KITITAS COUNTY

MEMORANDUM

TO: All Staff
FROM: Public Works Plan Review Team
DATE: August 22, 2025
SUBJECT: RU-25-00002 Dvorak

SHEET NUMBER: C-1.0

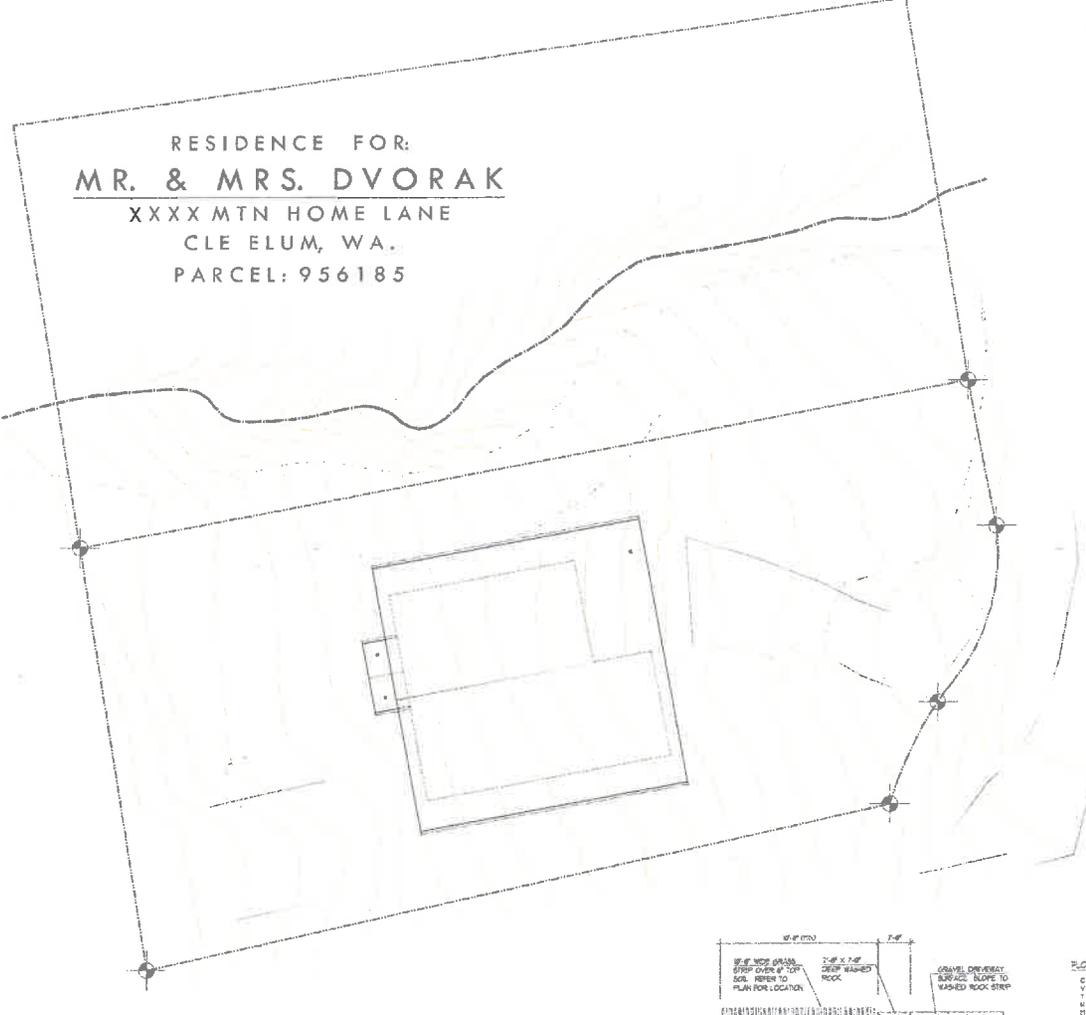
ACCESS	<ol style="list-style-type: none"> 1. An approved access permit shall be required from the Kittitas County Department of Public Works prior to creating any new driveway access or altering an existing access. 2. Applicant has an Issued Access Permit AA-25-00003. 3. Maintenance of driveway approaches shall be the responsibility of the owner whose property they serve. The County will not maintain accesses. 4. Private Road Certification required for Mountain Home Lane prior to certificate of occupancy. <p>In addition to the above-mentioned conditions, all applicable Kittitas County Road Standards apply to this proposal. Access is not guaranteed to any existing or created parcel on this application. (RC)</p>
ENGINEERING	Except as exempted in KCC 14.05.060, no grading or filling upon a site involving more than one hundred (100) cubic yards shall be performed without a grading permit from the County Engineer or Public Works designee (KCC 14.05.050). An application for grading in excess of five hundred (500) cubic yards shall be accompanied by an engineered grading plan (KCC 14.05.080). This grading plan will be under a joint review with the City of Ellensburg. (CBP)
